From: Laura Gibbons
Sent: 05 July 2019 15:39
To: Planning.Responses <Planning.Responses@arun.gov.uk>
Cc: Simon Davis <Simon.Davis@arun.gov.uk>
Subject: RE: Planning Consultation on: BE/69/19/OUT

Engineers Comments Regarding Surface Water Drainage

Description of Works: Outline planning application with all matters reserved except access for 31 No. houses and flats with car parking, landscaping and associated infrastructure & access off Shripney Road (A29), all following the demolition of the existing dwelling & outbuildings - This application is a Departure from the Development Plan

Proposed Access Drawing 160818-07B

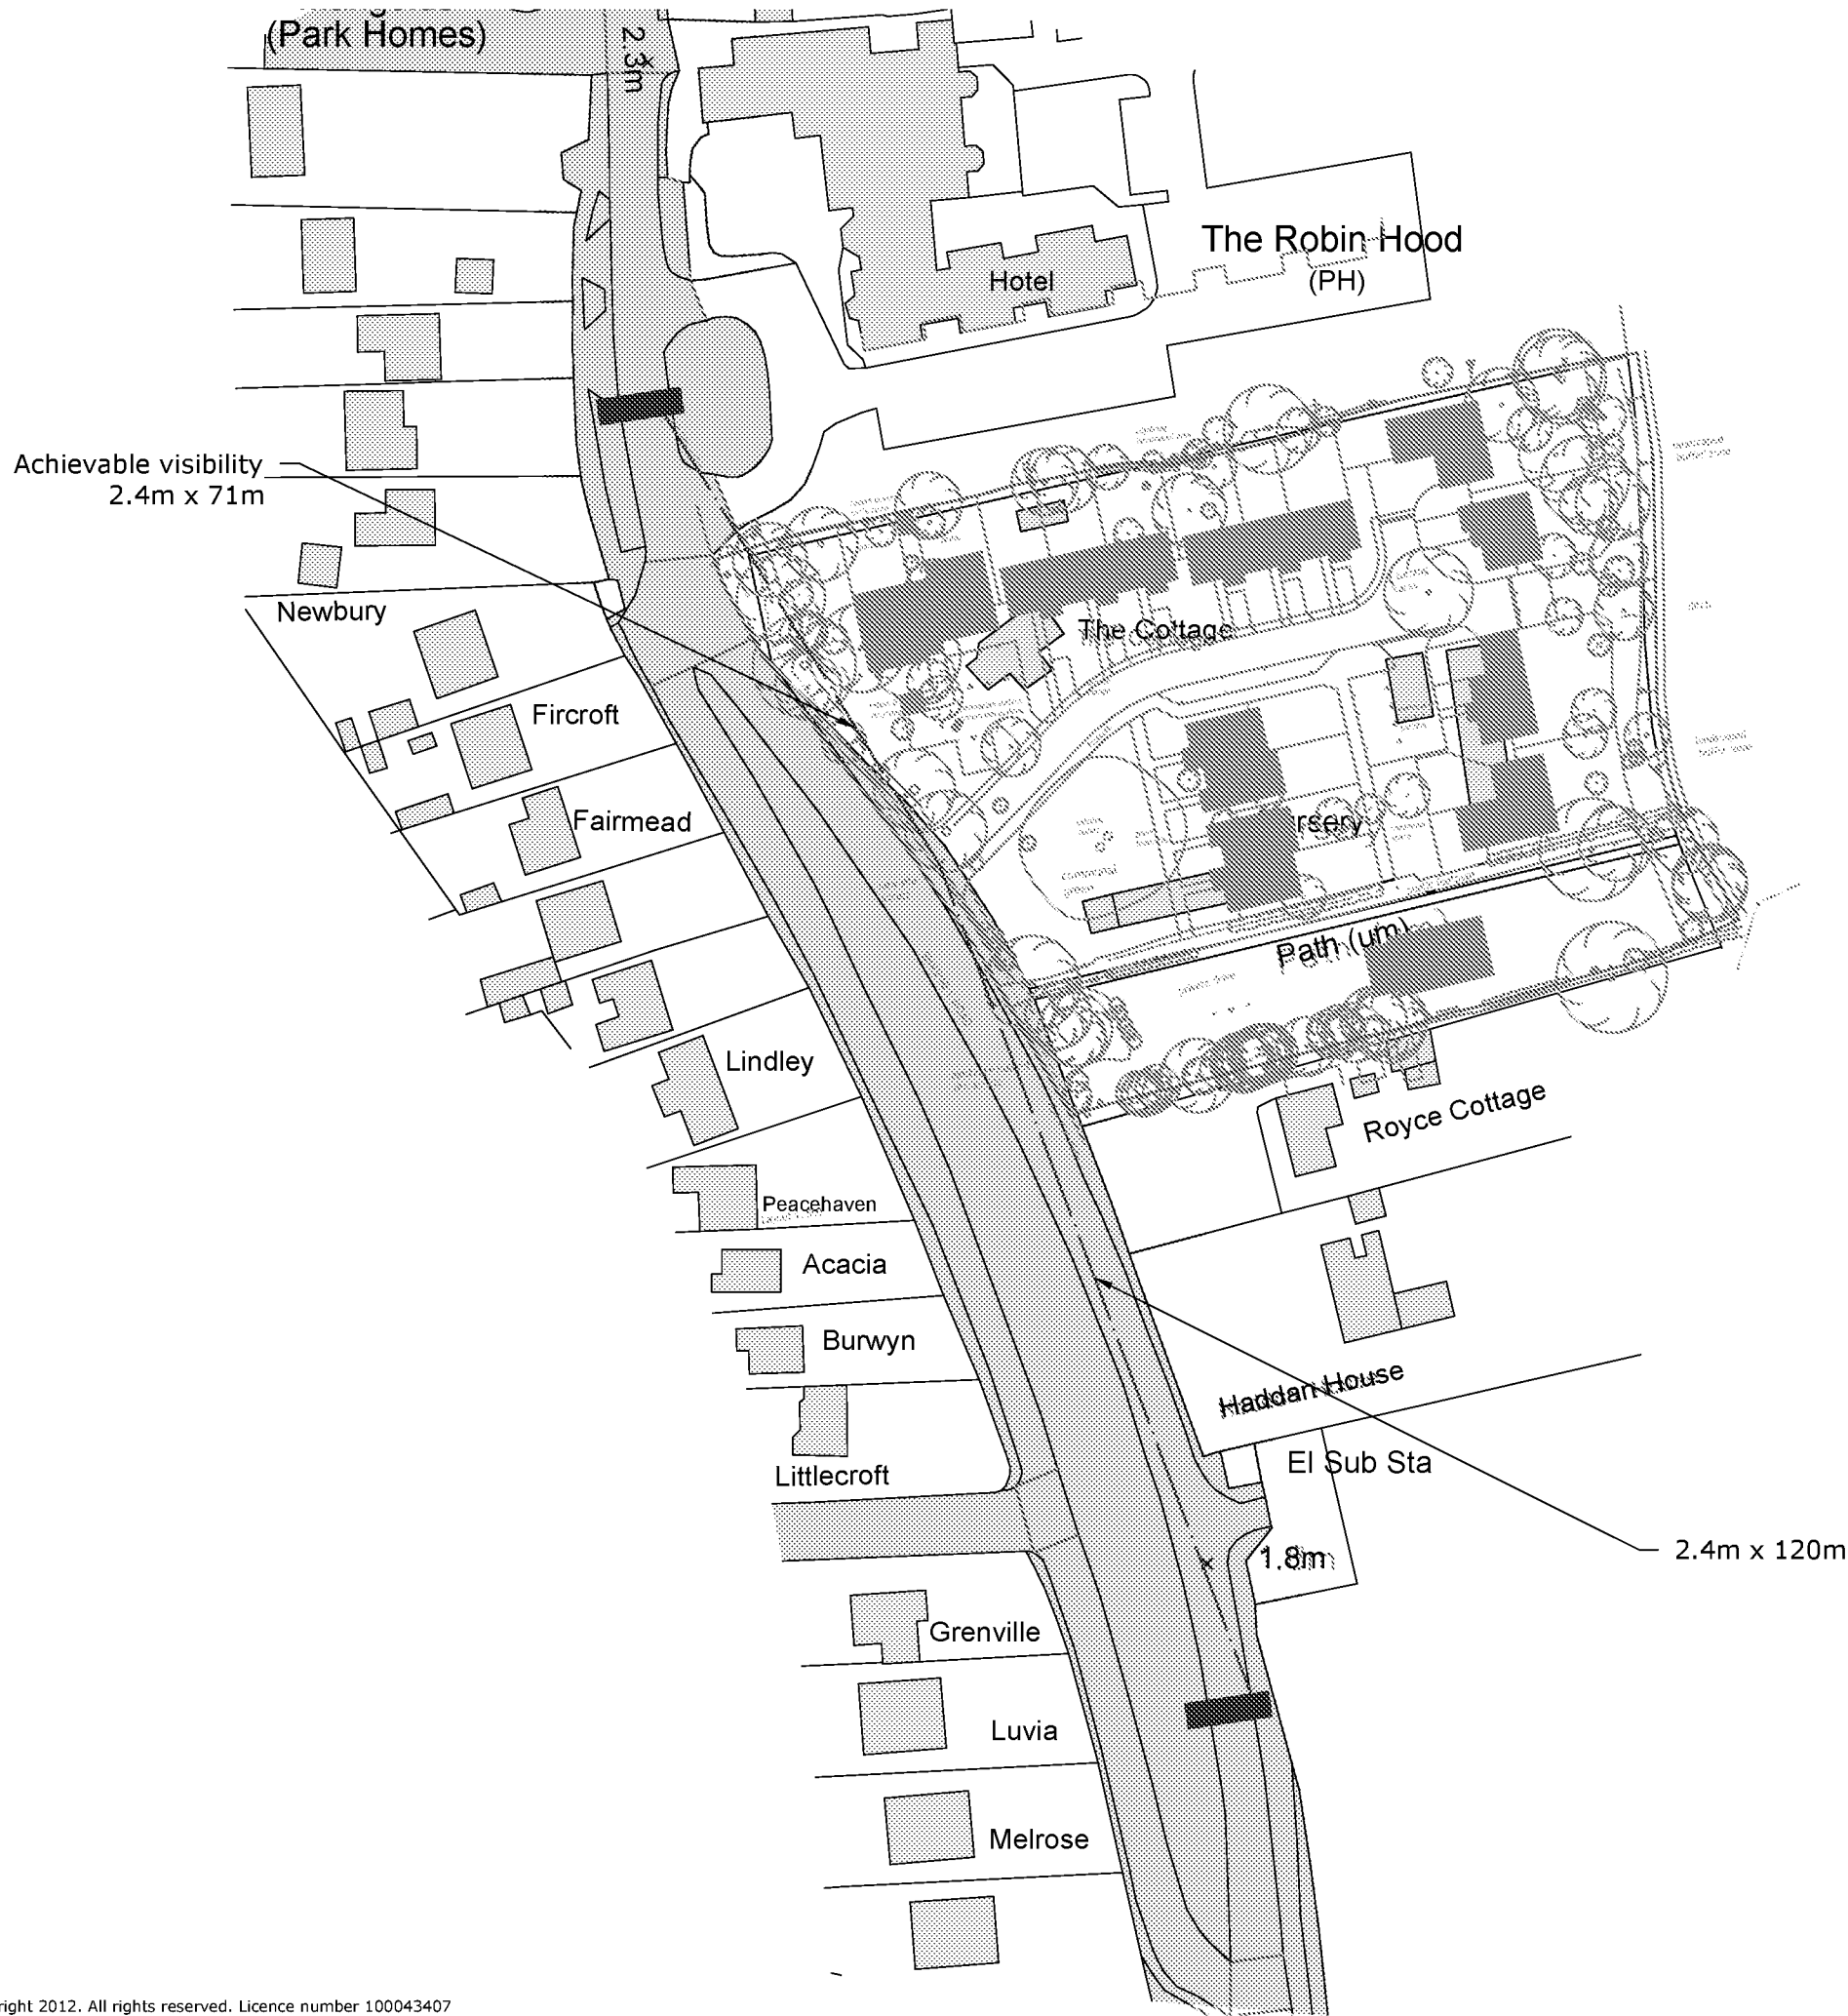
There are watercourses to the west and to the east of the site. It appears that in order to form the accessway a significant length of culverting will be required. This will require land drainage consent. The length of this culvert should be kept to an absolute minimum.

"The development shall not proceed until details have been submitted to and approved in writing by the Local Planning Authority for any proposals: to discharge flows to watercourses; or for the culverting, diversion, infilling or obstruction of any watercourse on or adjacent to the site. Any discharge to a watercourse must be at a rate no greater than the pre-development run-off values. No construction is permitted, which will restrict current and future land owners from undertaking their riparian maintenance responsibilities in respect to any watercourse or culvert on or adjacent to the site."
